# KITITAS COUNTY

## DEPARTMENT OF PUBLIC WORKS

### MEMORANDUM

**TO:** All Staff  
**FROM:** Public Works Plan Review Team  
**DATE:** February 12, 2026  
**SUBJECT:** BL-26-00001 Fields

RECORD OF SURVEY

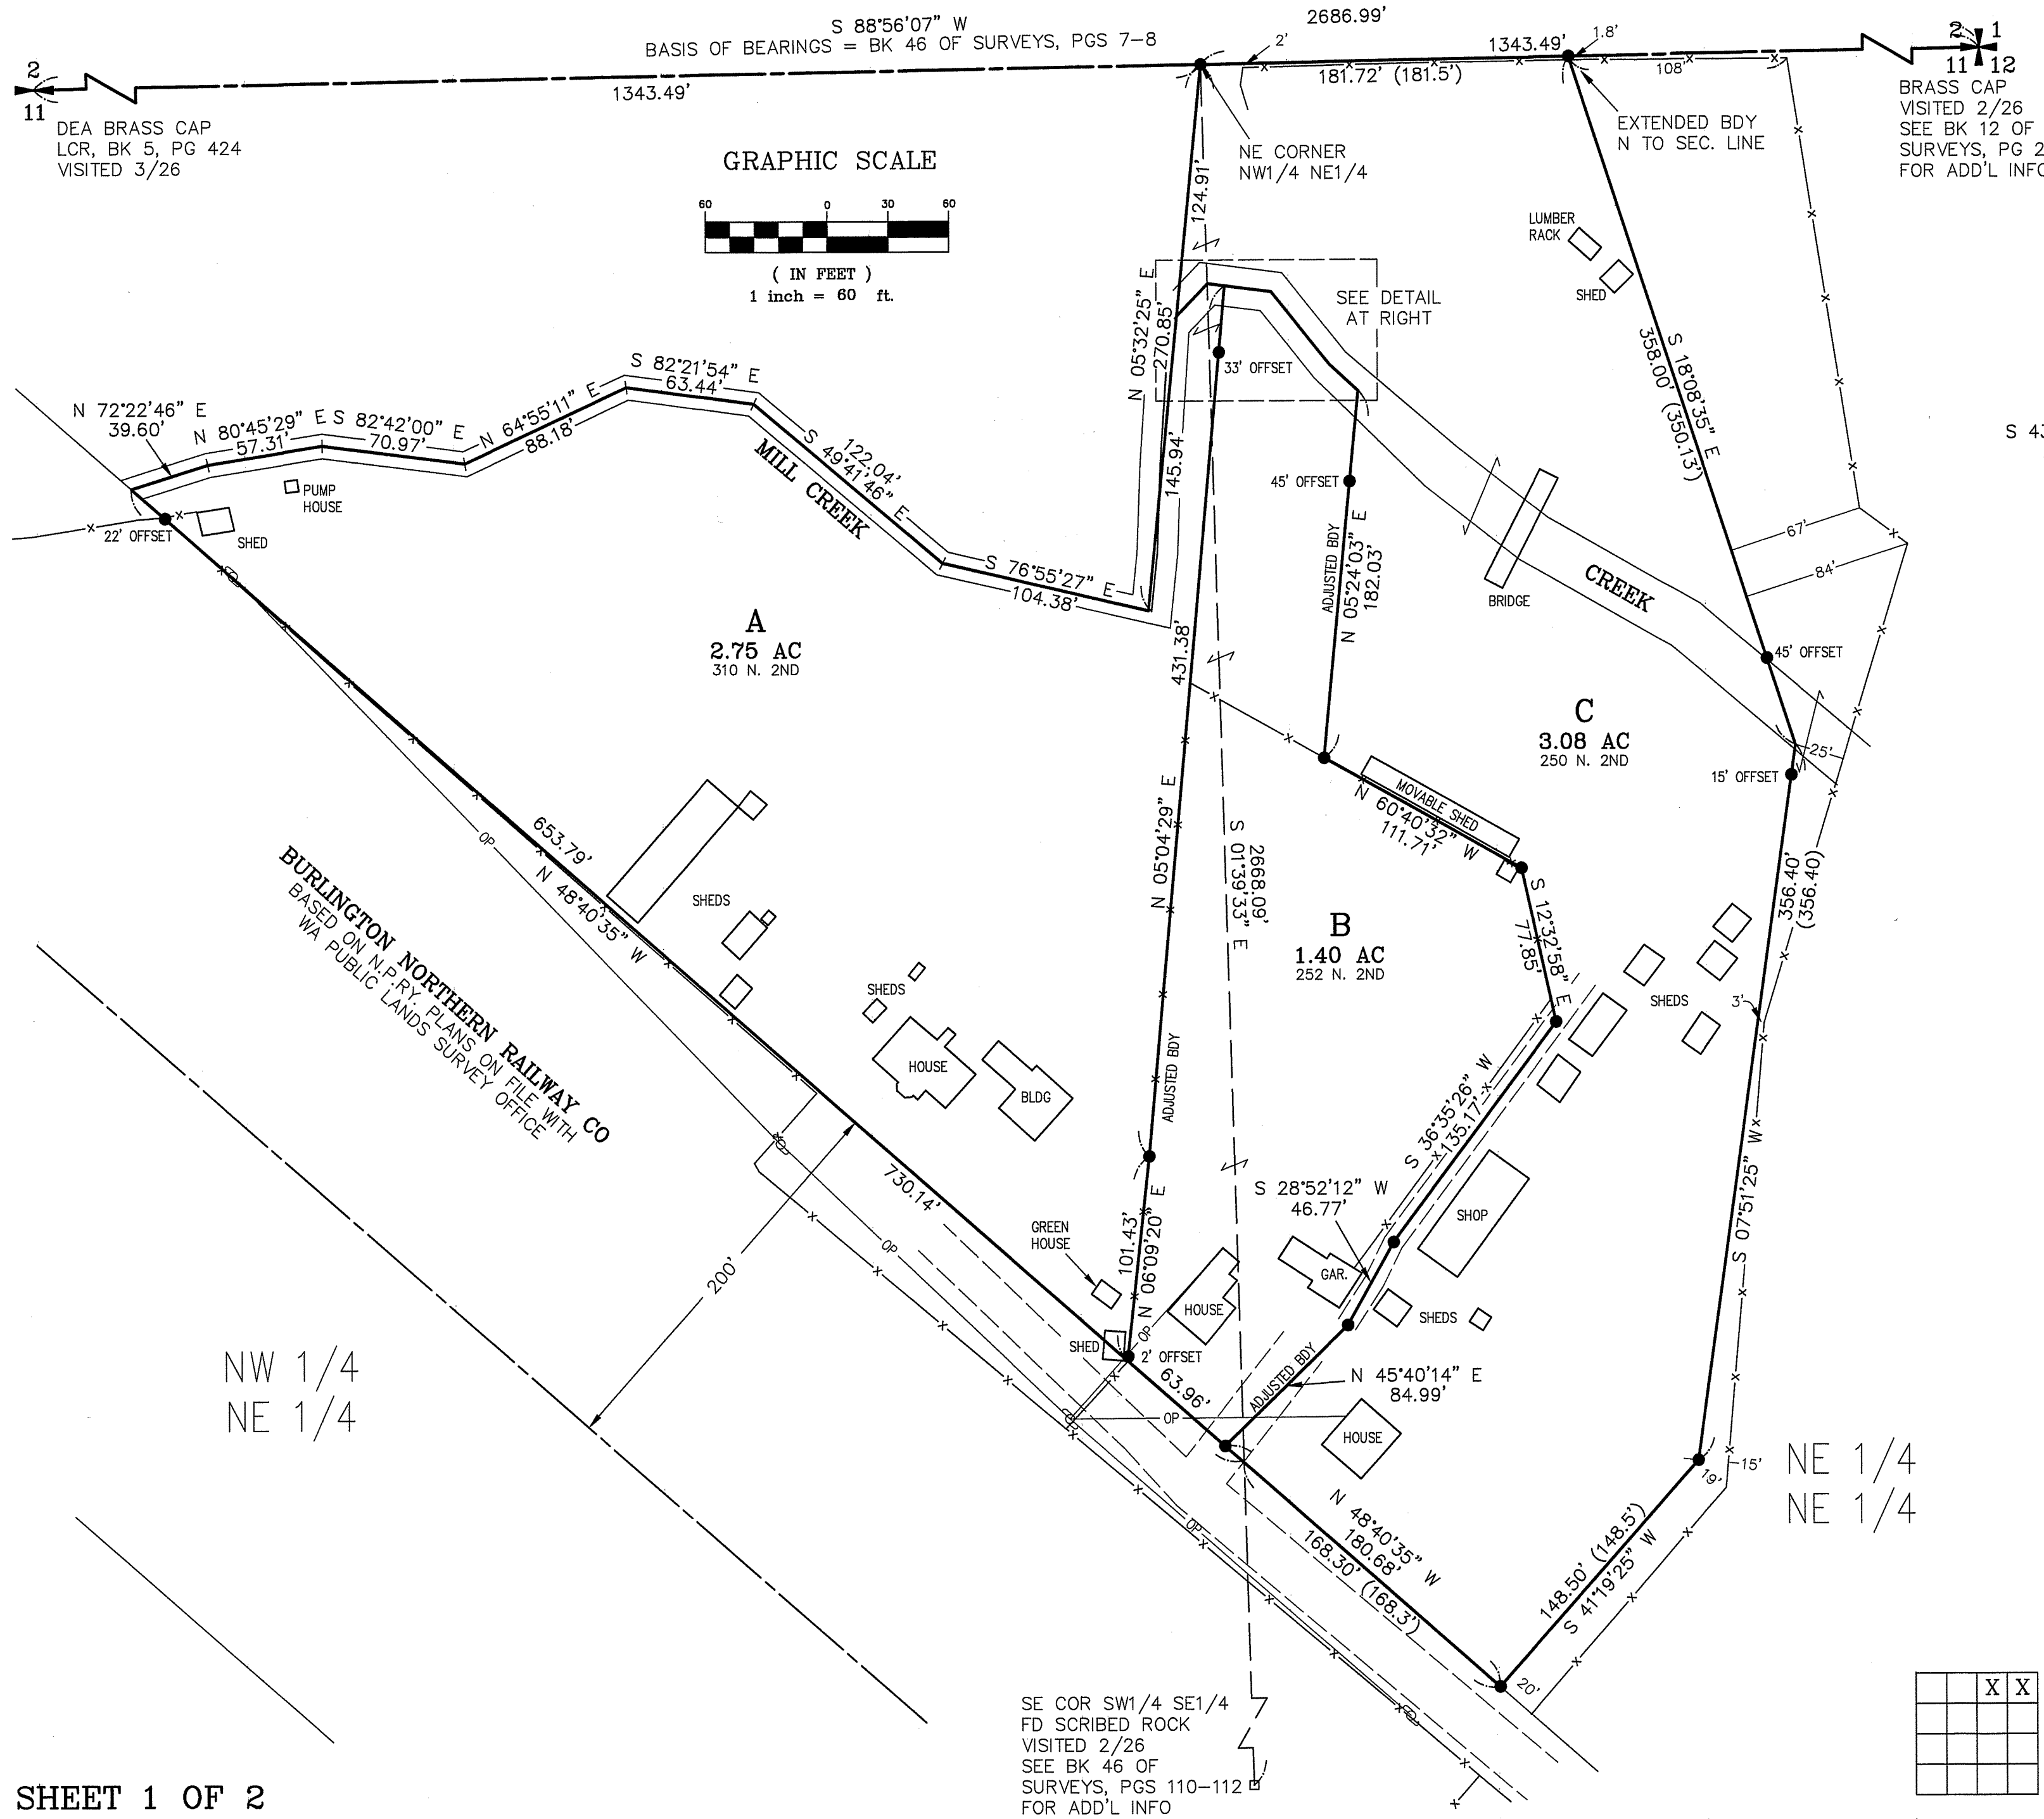
<b>ACCESS</b>	<ol style="list-style-type: none"> <li>1. An approved access permit shall be required from the Kittitas County Department of Public Works prior to creating any new driveway access or altering an existing access.</li> <li>2. Maintenance of driveway approaches shall be the responsibility of the owner whose property they serve. The County will not maintain accesses.</li> <li>3. Any further subdivision or lots to be served by proposed access may result in further access requirements. See Kittitas County Road Standards.</li> <li>4. Provide proof of easement for shared driveway access to lots prior to final approval.</li> </ol> <p>In addition to the above-mentioned conditions, all applicable Kittitas County Road Standards apply to this proposal. Access is not guaranteed to any existing or created parcel on this application</p> <p>OF NOTE:  Parcel 745933 to retain address 310 N 2<sup>nd</sup> St ; It is unclear which home will retain 250 and 252 N 2<sup>nd</sup> St on parcel 685933.</p>

<b>ENGINEERING</b>	<p>Except as exempted in KCC 14.05.060, no grading or filling upon a site involving more than one hundred (100) cubic yards shall be performed without a grading permit from the County Engineer or Public Works designee (KCC 14.05.050). An application for grading in excess of five hundred (500) cubic yards shall be accompanied by an engineered grading plan (KCC 14.05.080). (CBP)</p>
<b>SURVEY</b>	<p>As the application does not contain a survey map, comments are herein reserved until final. (JT)</p>
<b>TRANSPORTATION CONCURRENCY</b>	<p>No transportation concurrency management application is required for this project as described.</p>
<b>FLOOD</b>	<p>Parcels 675933, 685933, and 745933 are completely within the FEMA mapped special flood hazard area (1 percent annual chance flood zone). All development within the special flood hazard area requires a floodplain development permit, including structures that are exempt from a building permit, and must follow the guidelines within KCC 14.08. (SC)</p>
